GRADING AND EROSION CONTROL PLAN

WYOMING ESTATES SUBDIVISION EL PASO COUNTY, CO

DRAINAGE, GRADING
AND EROSION
CONTROL PLAN

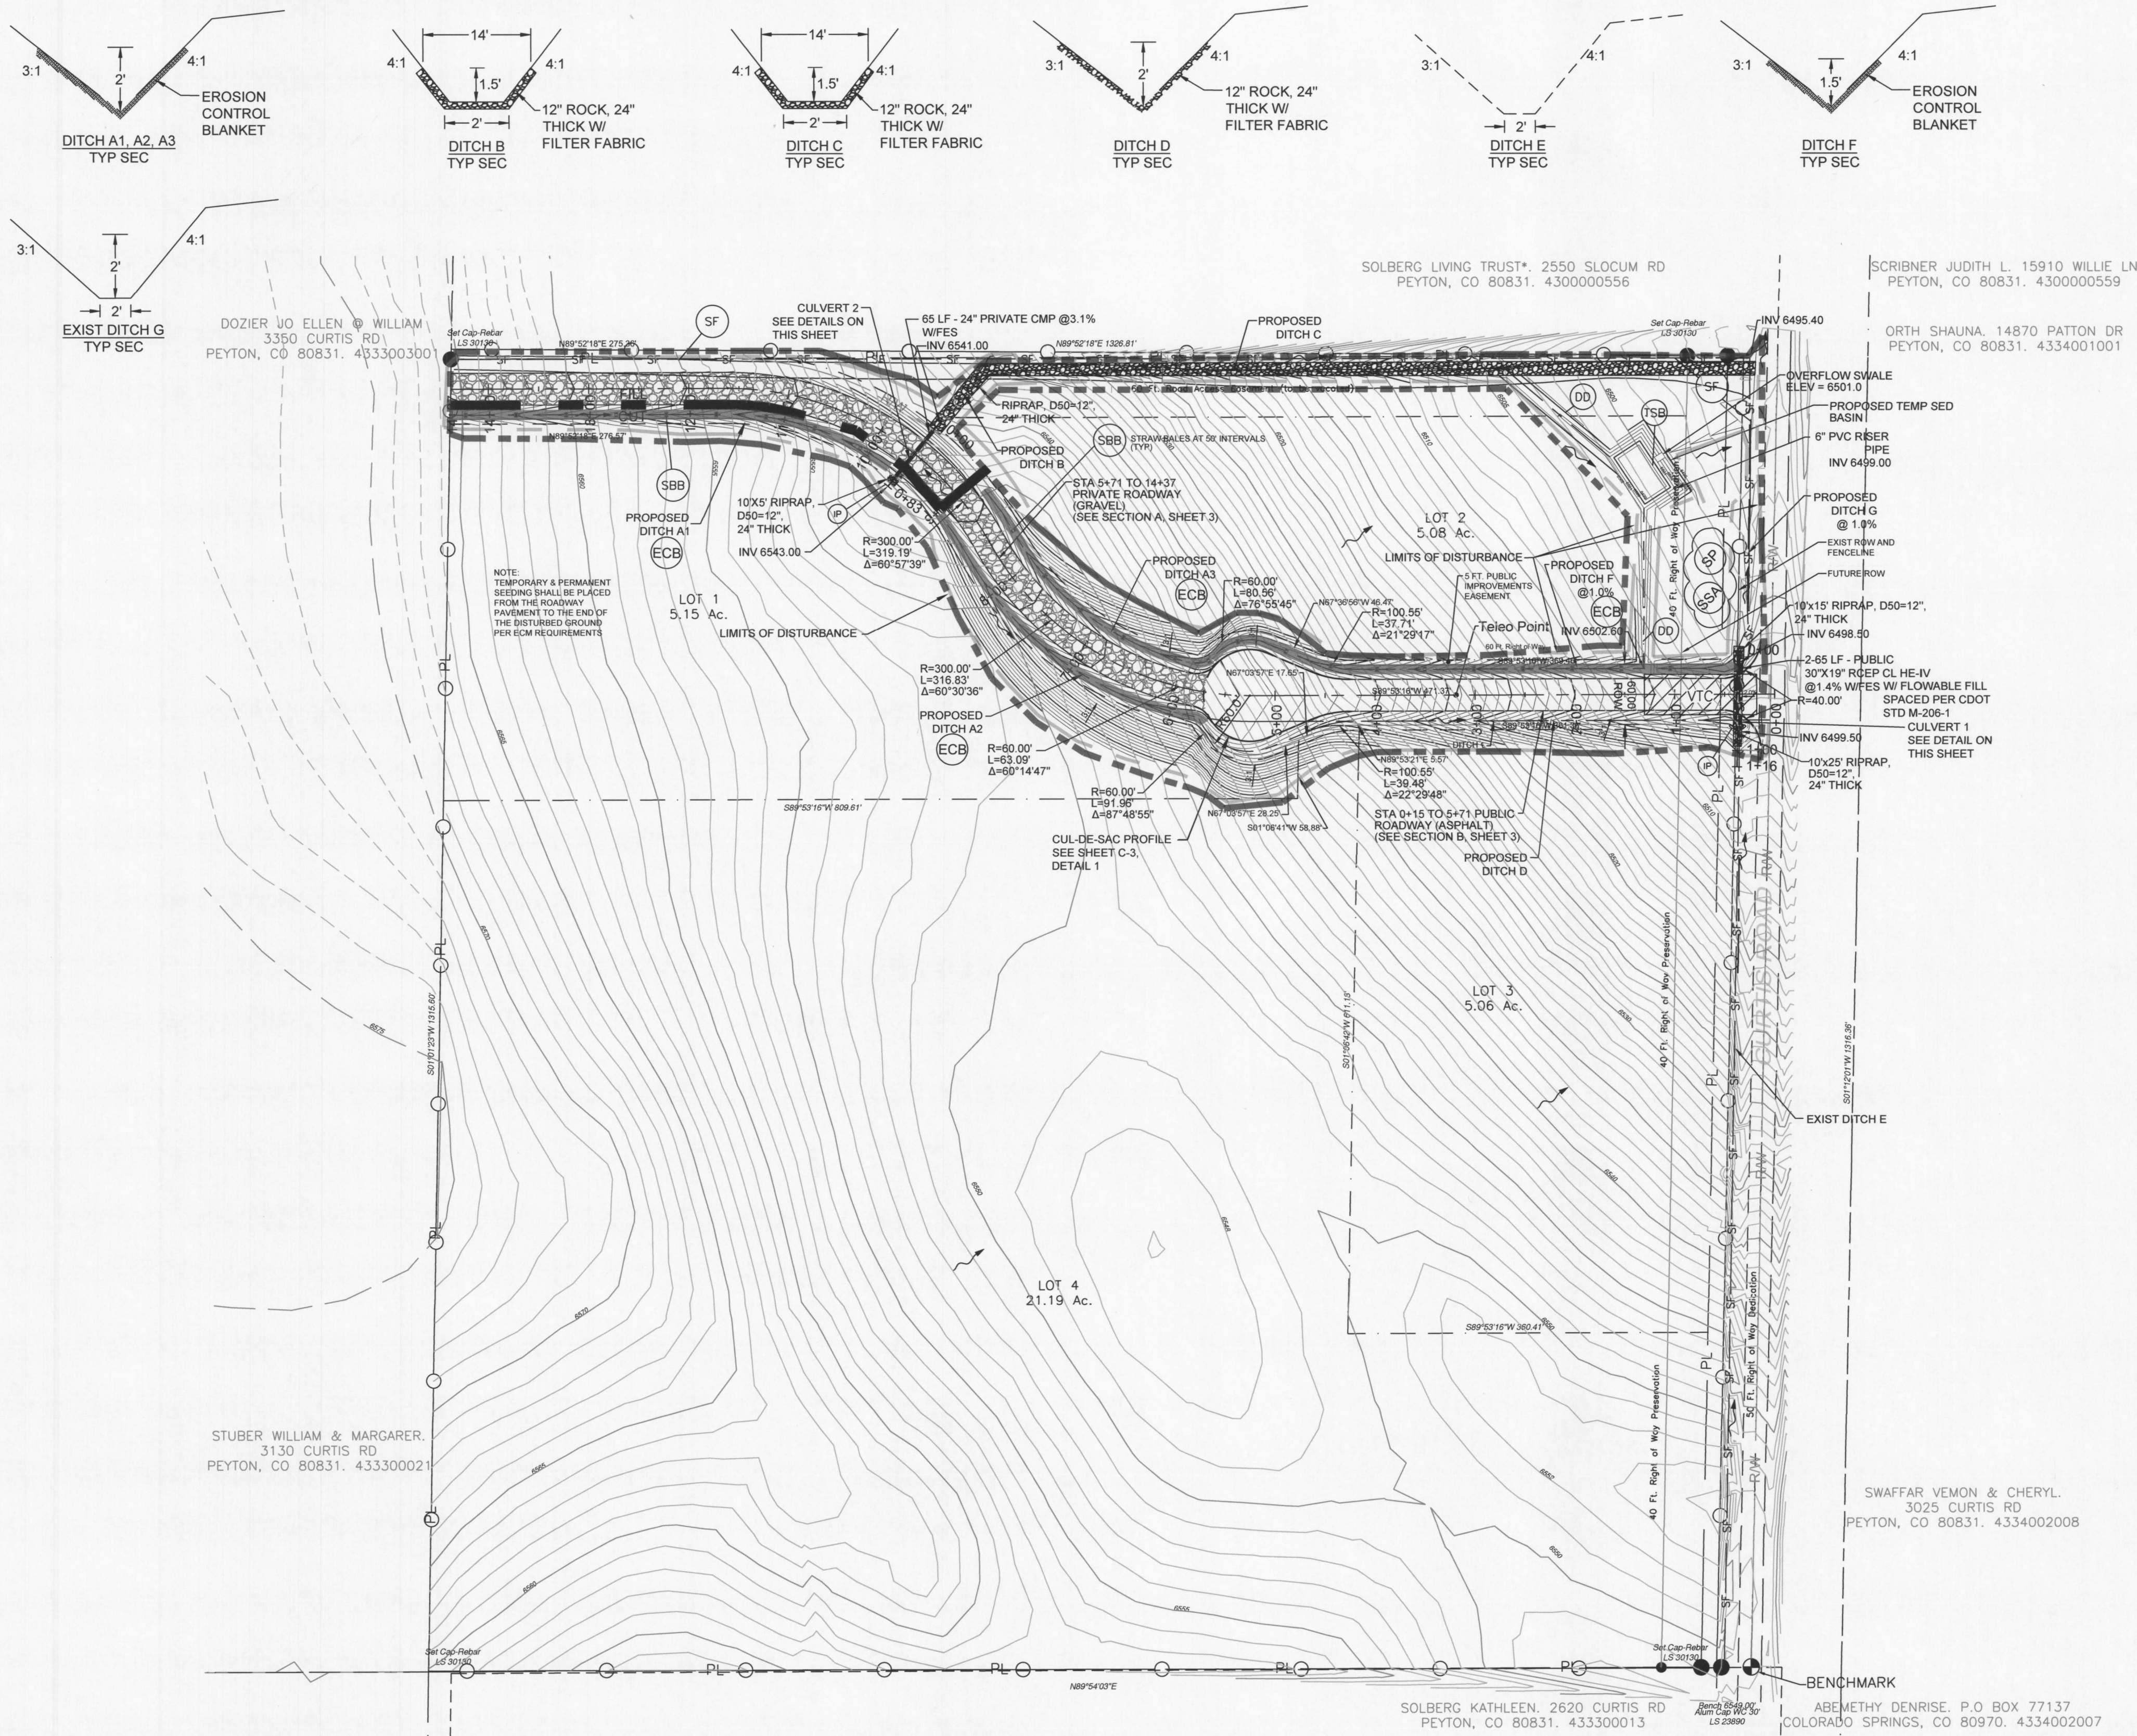
Identify the required and provided sediment basin volume and all riser pipe construction information.

Show the location of the staging area and provide details for inlet protection and stabilized staging area.
